**Re: Albuquerque Collegiate Charter School
Neighborhood Impact Assessment (L09D032)**
Engineer's Stamp DRAFT-No date
Via email: jbecker@tierrawestllc.com

The subject Neighborhood Impact Assessment (Study) DRAFT received on December 13, 2024, has been reviewed by the City of Albuquerque Planning Development Transportation Section. Transportation provides the following comments to be addressed.

CONCEPTUAL
TRAFFIC
CIRCULATION
LAYOUT -
CAMPUS PLAN

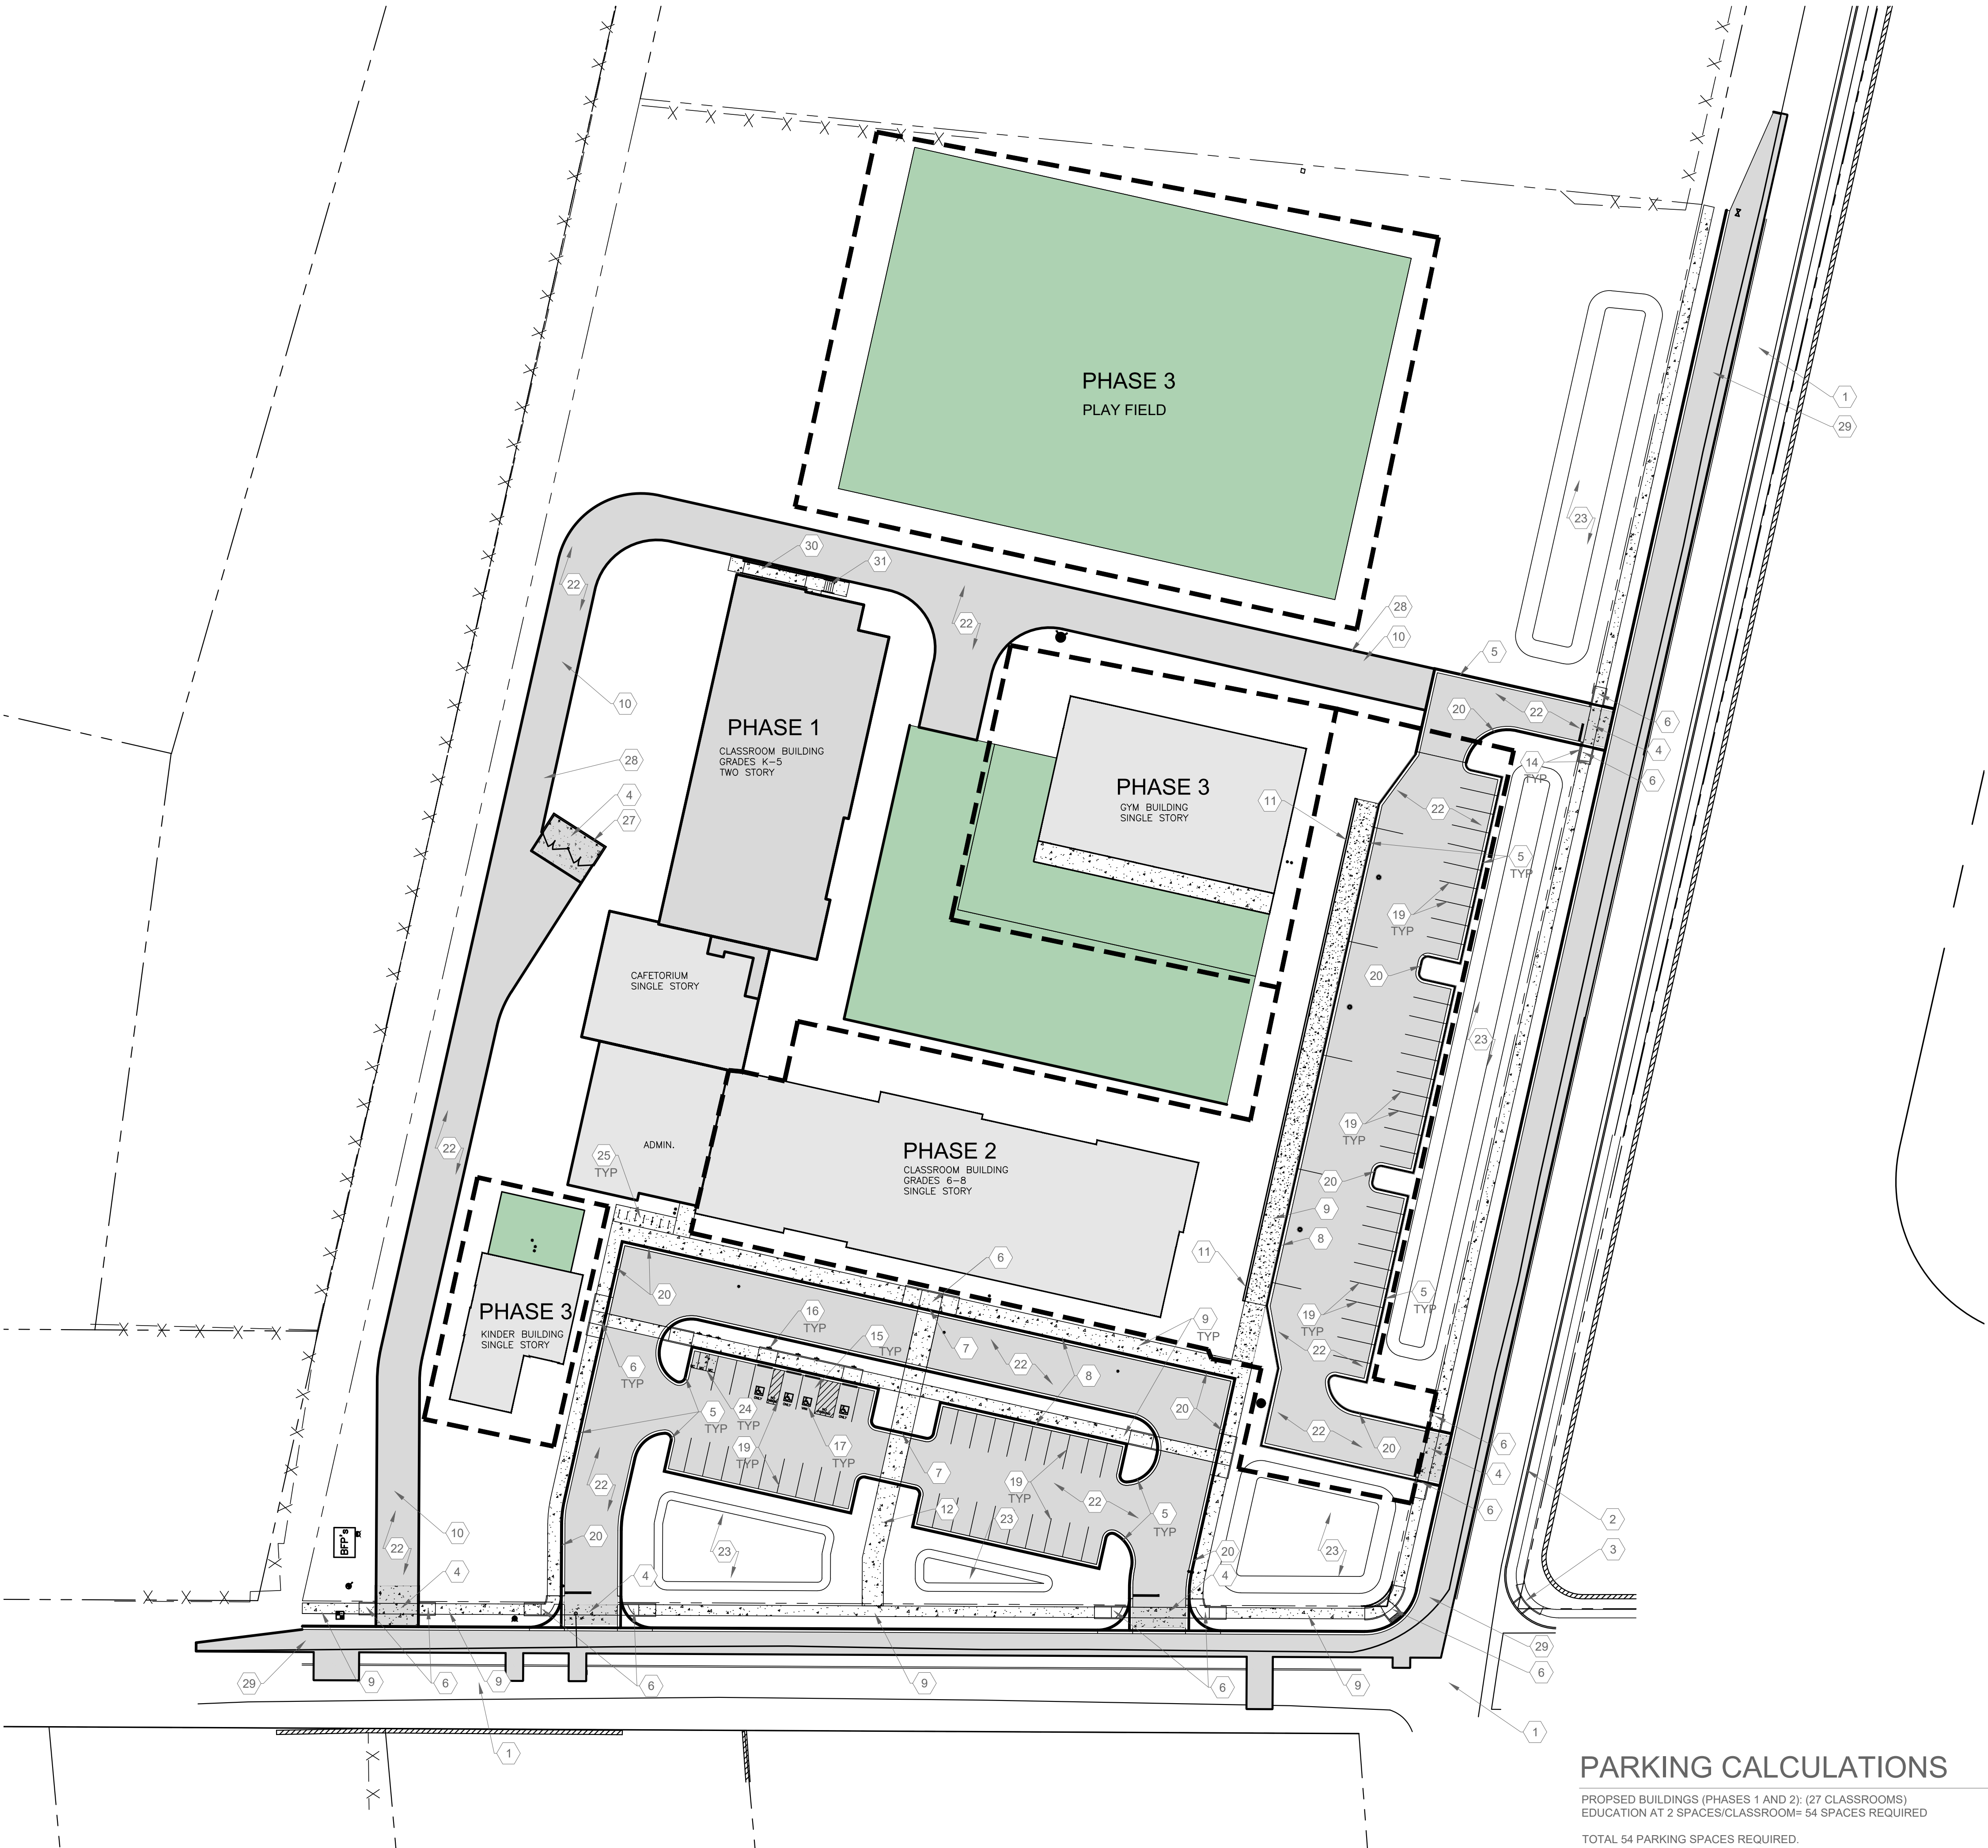
1. Include distances from intersections to driveways and a directional arrow for the south parking lot on the Site Plan. Site plans are not constrained to fit on the 8.5x11 size paper of the Study. Provide a Site Plan minimum size of 11"x17".

2. Identify the Phase on the Masterplan for the south parking lot.
3. Include the queue length, in addition to the delay, for LOS F turning movements in the "Impacts" section.
